Submission to An Coimisiún Pleanála

SID Project :Shancloon Wind Farm

Reference : 323699

Date: 16 November 2025

Figure A8.21: Prevailing Night time Background (L_{A90}) Noise Levels at N8

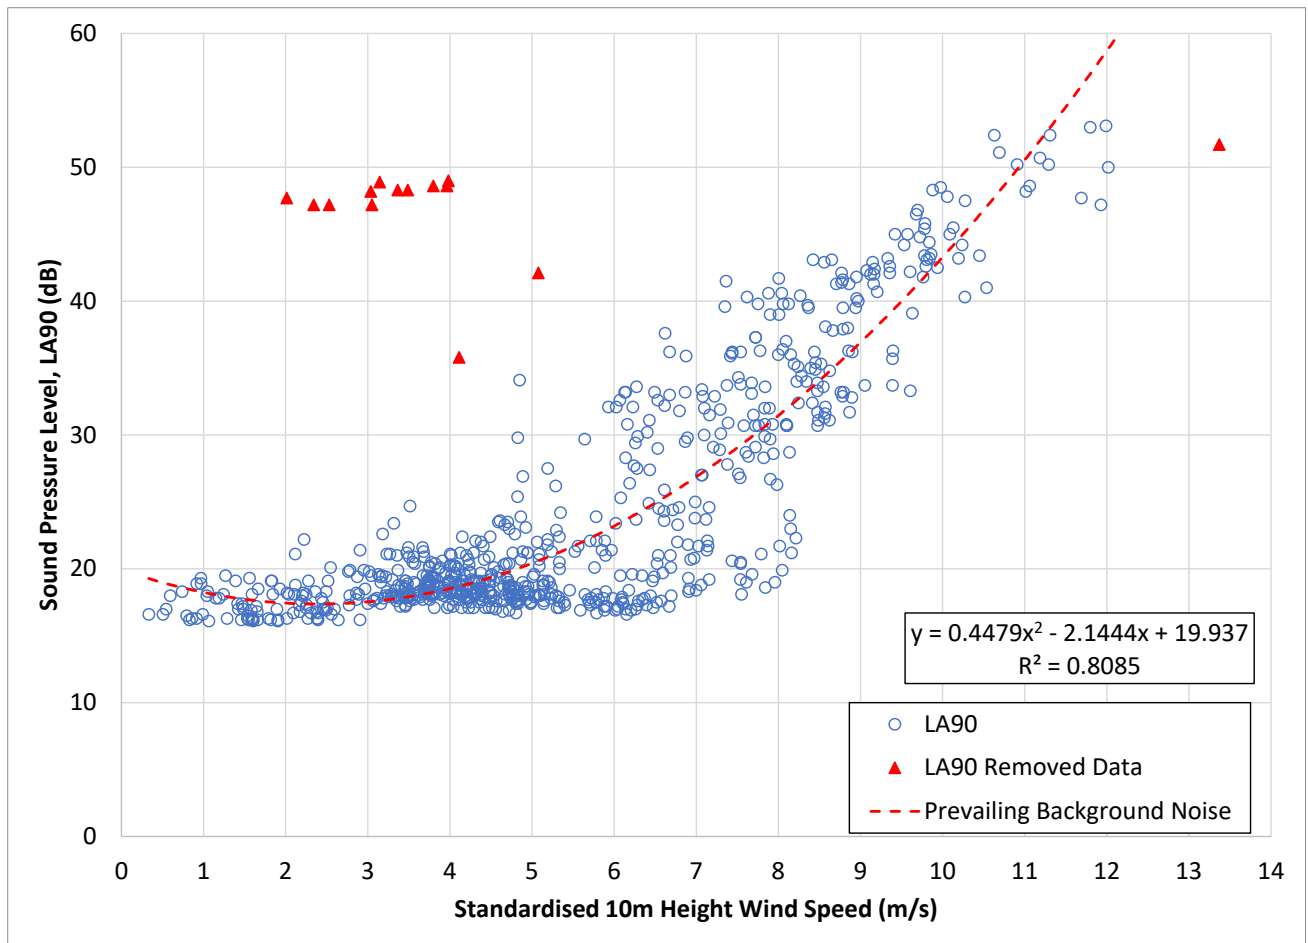
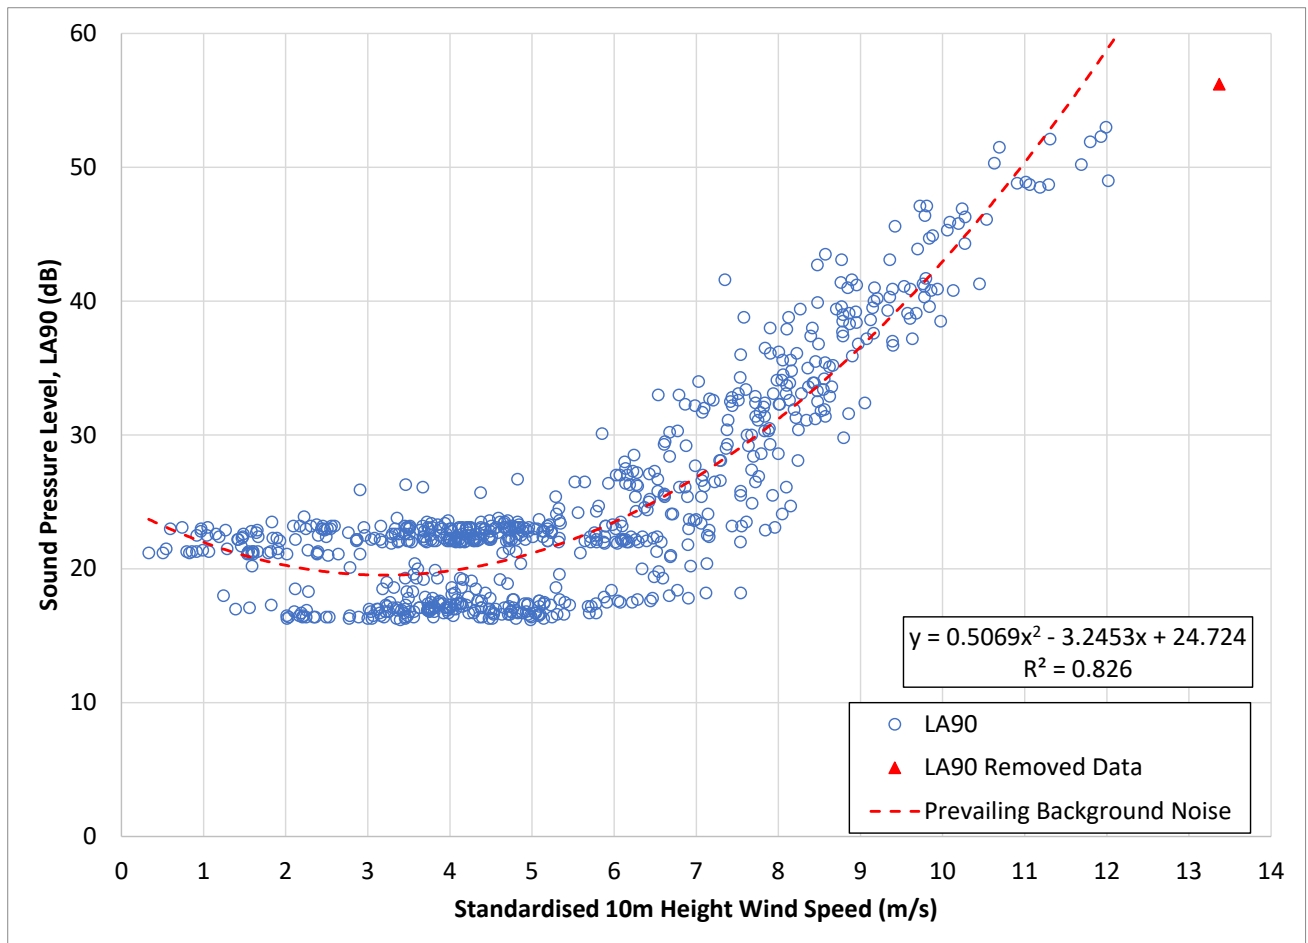
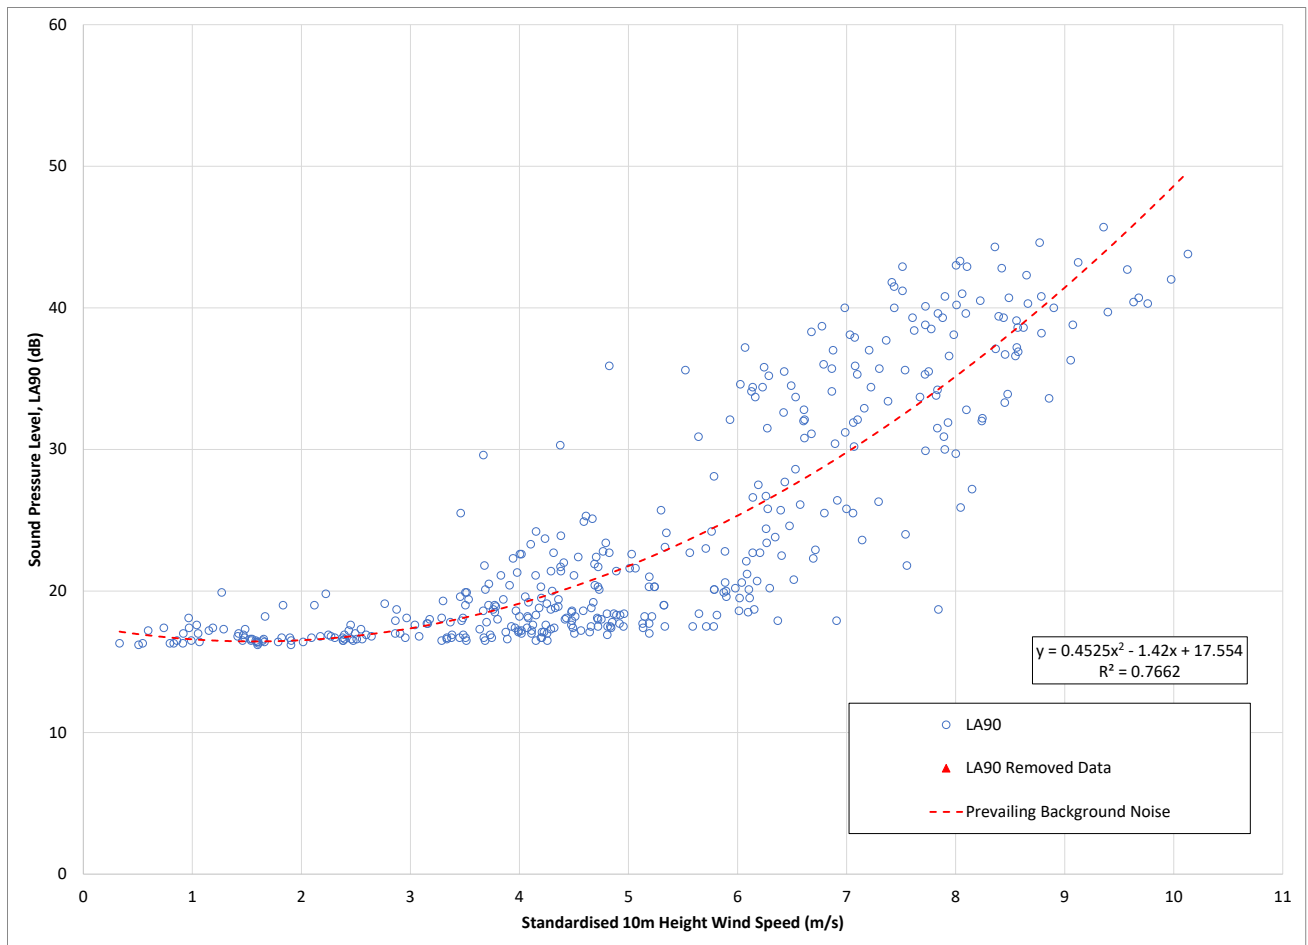
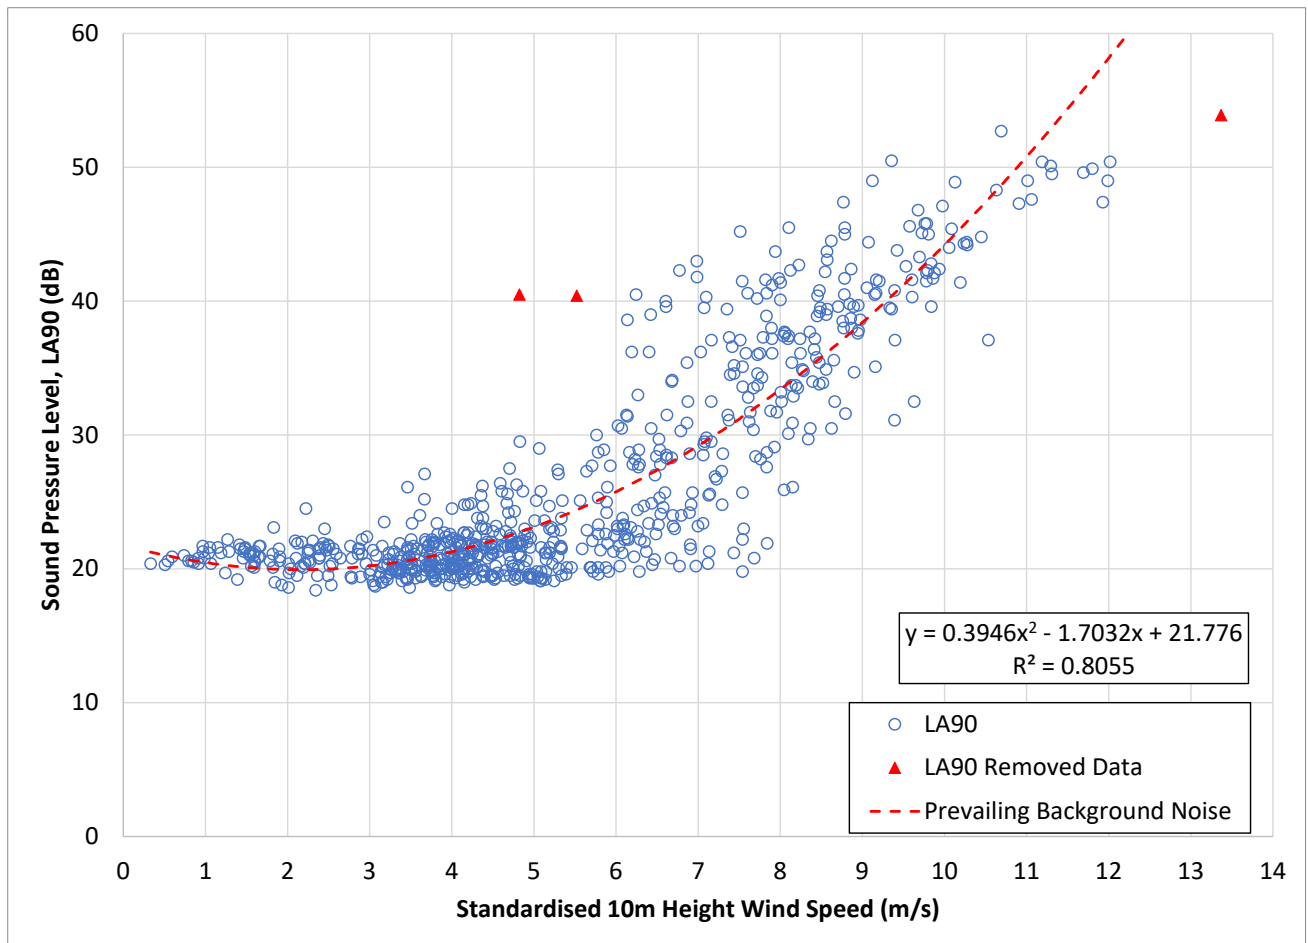
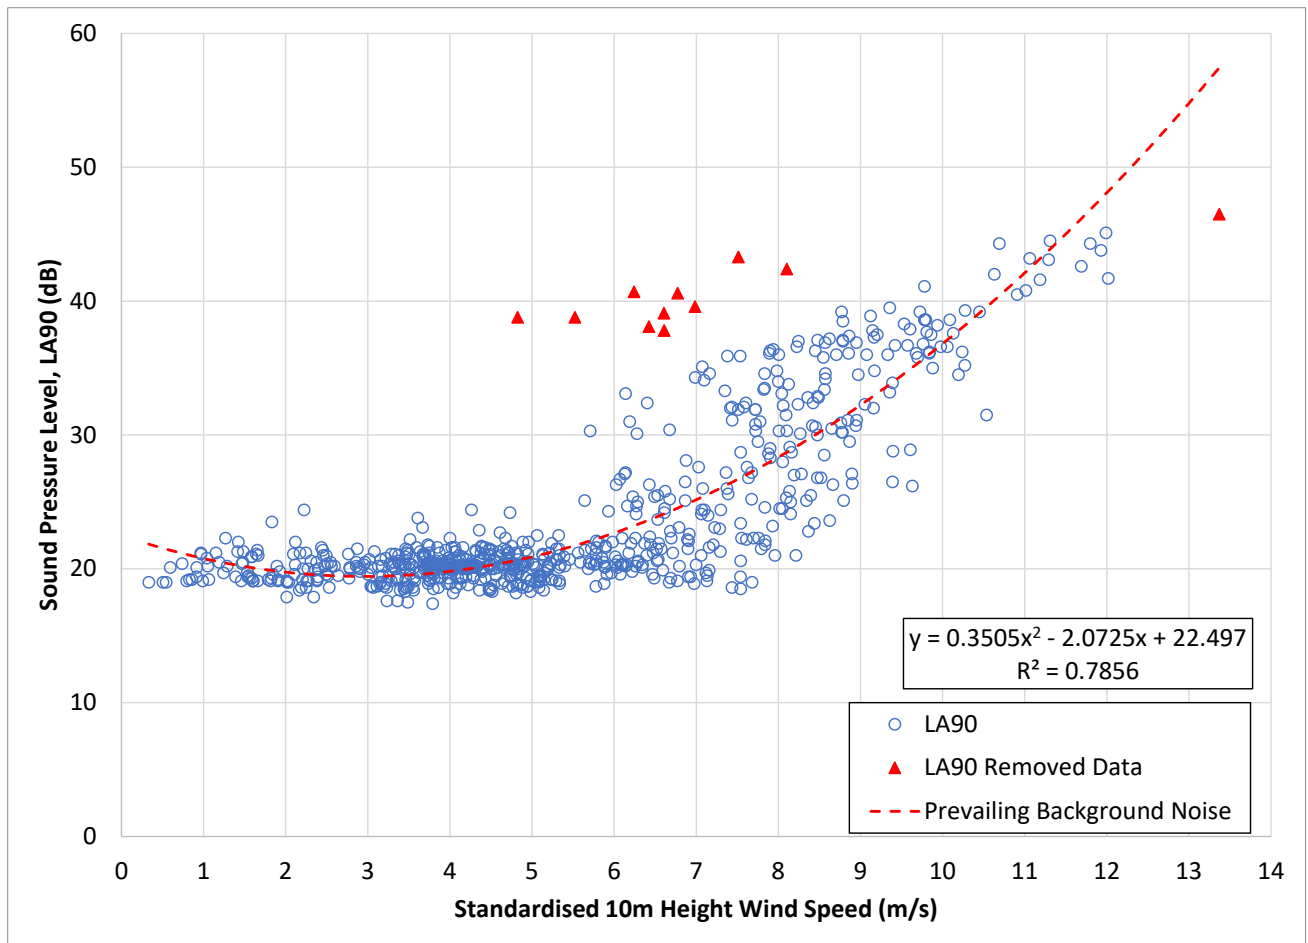
- Separation distances below 7x rotor diameter; only two turbine pairs comply (p.21).
- Noise limits exceed permissible nighttime levels; cumulative turbulence effects ignored (pp.36–41).

- **Noise Assessment:** Nighttime permissible noise levels exceeded; cumulative effects ignored (p.36).
- **Flooding & Karst Risk:** Impermeable surfaces and karst collapse risks underestimated (p.51).
